City of Albuquerque Stormwater Construction Site Inspection Report

ESC File No.	K10E060	Project Name:	7200 Bluewater		
NPDES Id. No.	NMR1003UT	Location:	7200 Bluewater		
7/27/2021	Owner	Contractor			
Operator	M & B Investments Ltd. Co.	GA Brunacini Construction			
Contact name & title	Angelo Brunacini	Angelo Brunacini			
e-mail	abrunacini@brunacini.com	abrunacini@brunacini.com			
Contact Phone #	505-833-2928	505-833-2928			
COA Inspector	Doug Hughes	Start/End Time:	2pm		
Construction Phase:	Earthwork				
Type of Inspection:	Regular	Storm Event	Past Storm Event >0.25"	311/Complaint	Follow Up
Weather at time of inspection?		clear	Temperature: ~		90
Estimated date of last storm 0.25" or greater		7/31/2021

ENGINEER'S SEAL RONALD R. BOHANNAN P.E. #7868	7200 BLUEWATER RD ALBUQUERQUE, NM	DRAWN BY pm
		DATE 8-4-21
	EROSION CONTROL PLAN	DRAWING 2020056-SWPPP
	TERRA WEST, LLC 5571 MIDWAY PARK PL NE ALBUQUERQUE, NEW MEXICO 87109 (505) 858-3100 www.tierrawestllc.com	SHEET # SW-1 JOB # 2020056

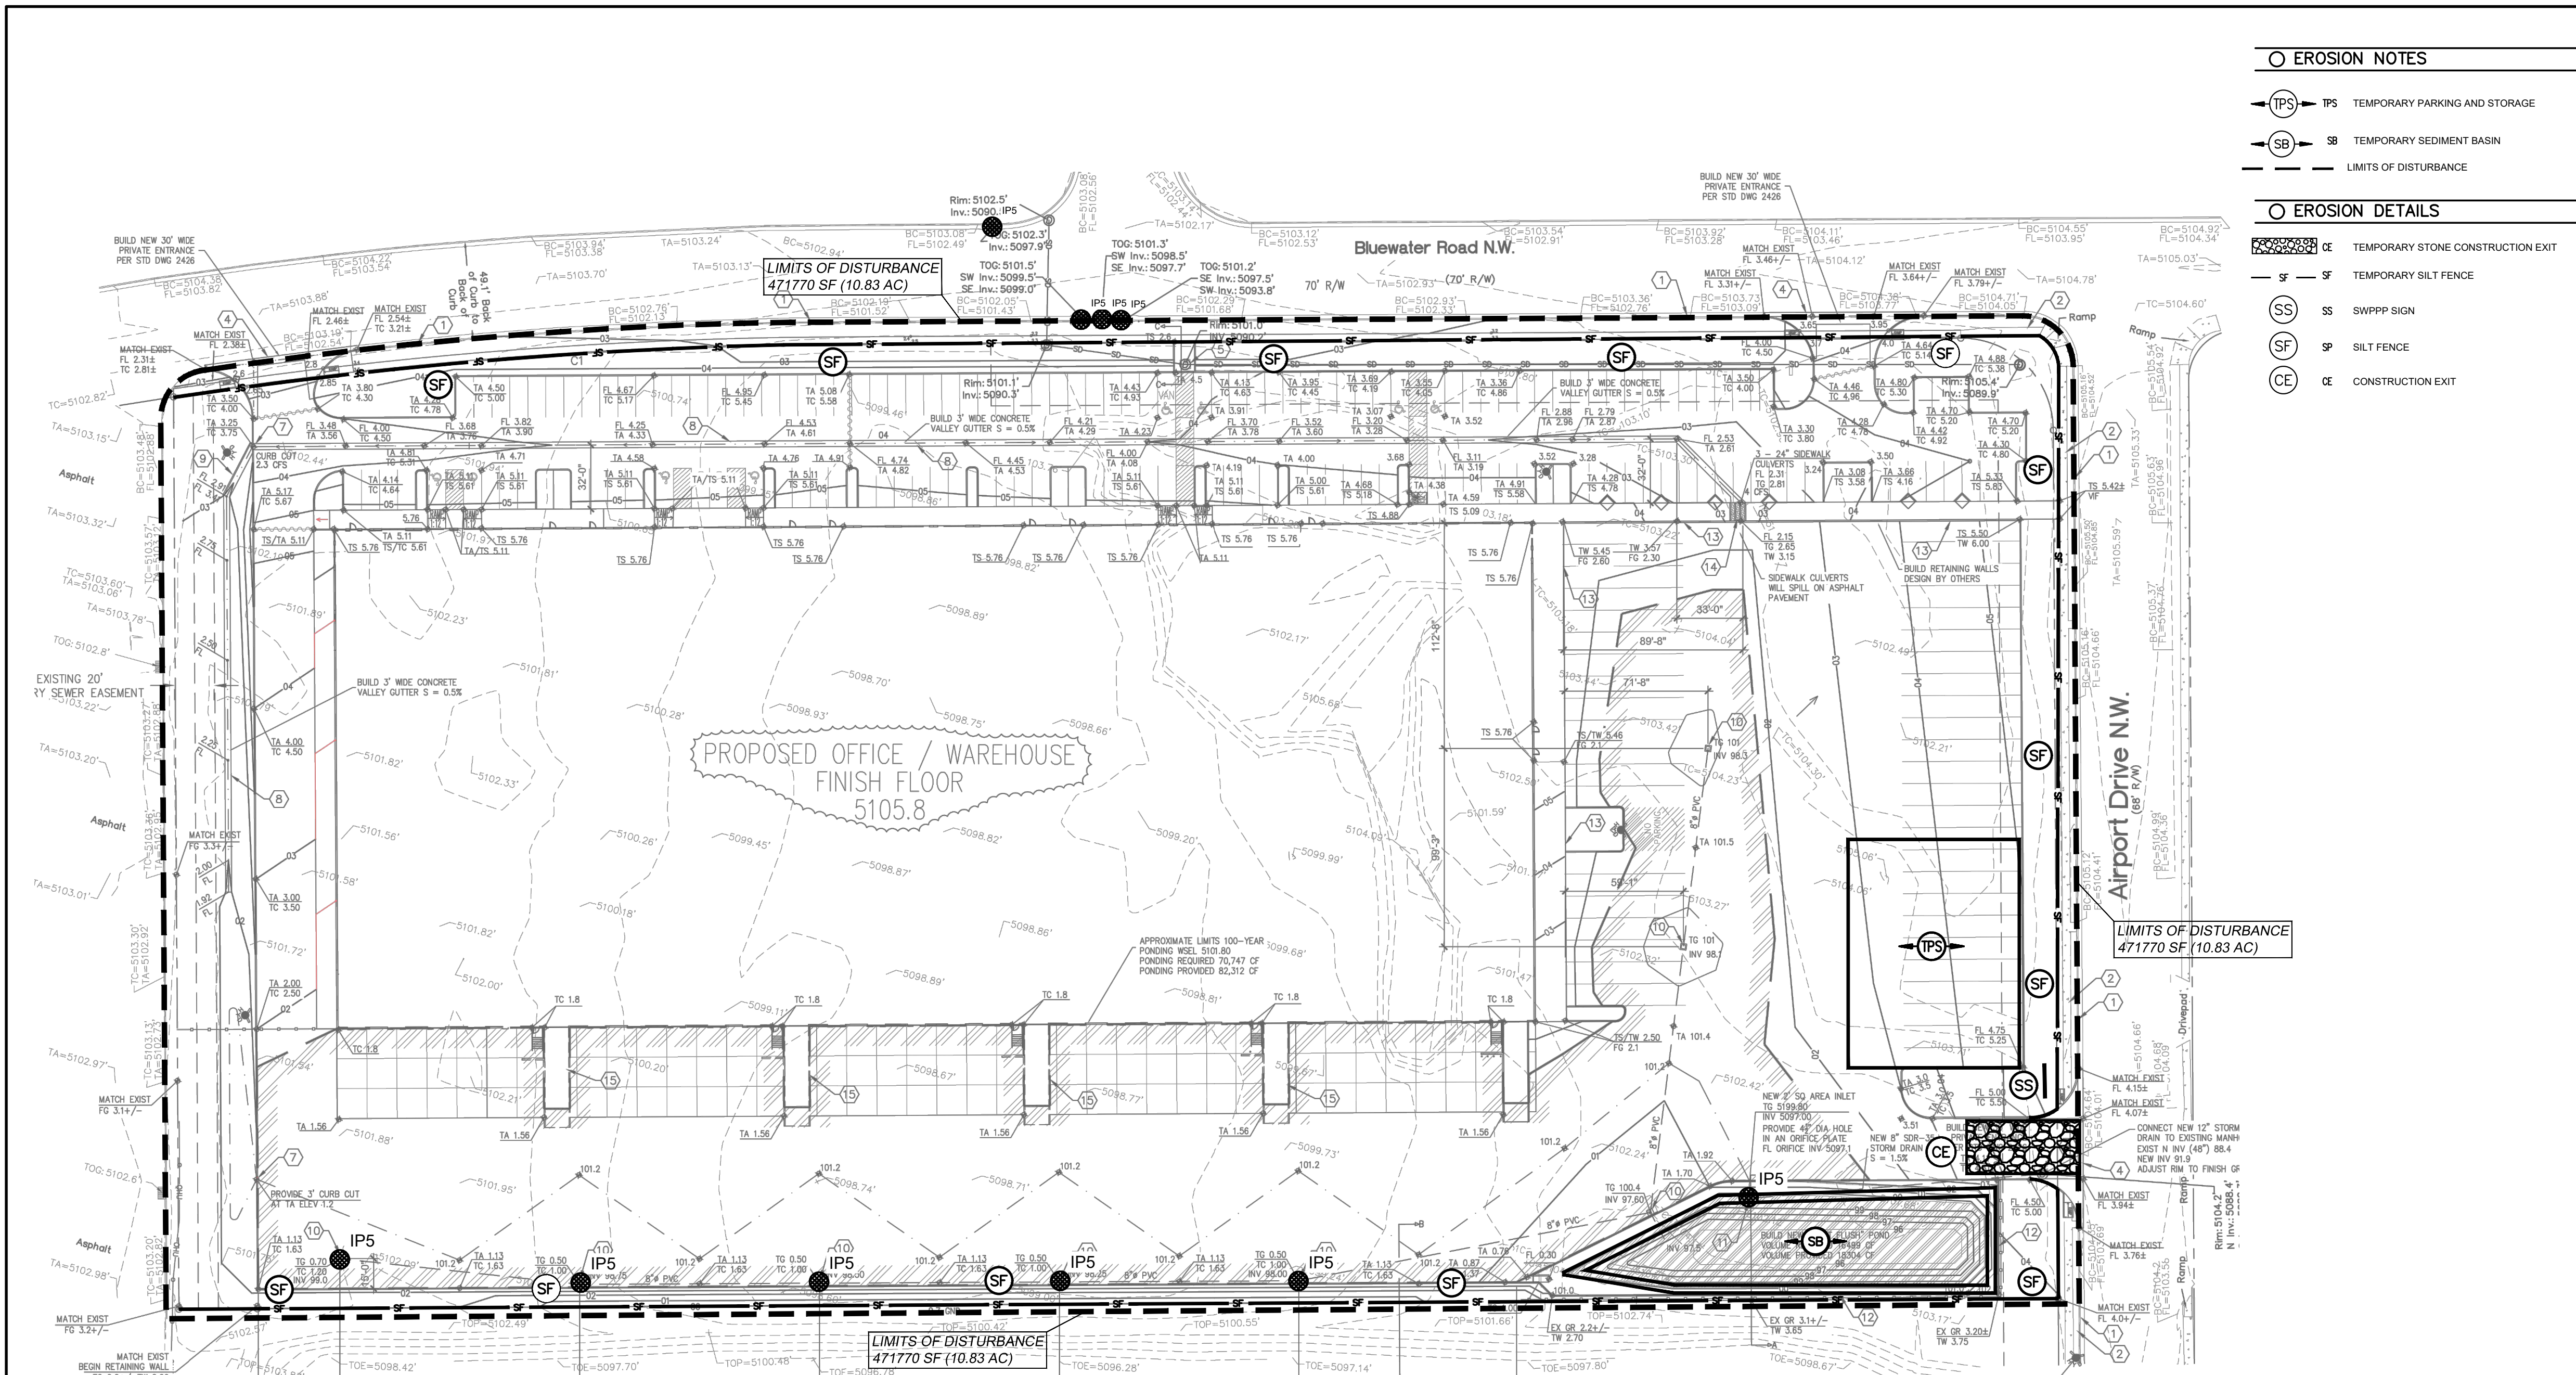
Item Number	Deficiency/ Corrective Action				
1	Permit coverage was not properly posted, ID # missing from sign, phone numbers on sign don't have SWPPP, Location of SWPPP not identified.				
2	SWPPP was not onsite though it eventually got there. It must be available onsite, and up-to-date. Map missing, Owner/Operator NOI and certification missing. SWQ Team not identified.				
3	Trackout and sediment in the street at entrance and near inlets. Water truck started washing street sediment into curb and maybe into inlets. Pickup and remove sediment from street and sidewalk daily. Never wash it into inlets!				
4	10' hole in north silt fence needs repair				
5

Notes:	Pad grading finished. Stem wall south not started yet. Trackout at hydrant on SE corner.
Entrance moved to SE corner.	
Borrow site Inspections missing, Franklins NOI for borrow in this SWPPP but no map?	
Borrow site has a separate SWPPP and a separate owner. G&D for APS Bus storage submitted, so who owns the borrow site?
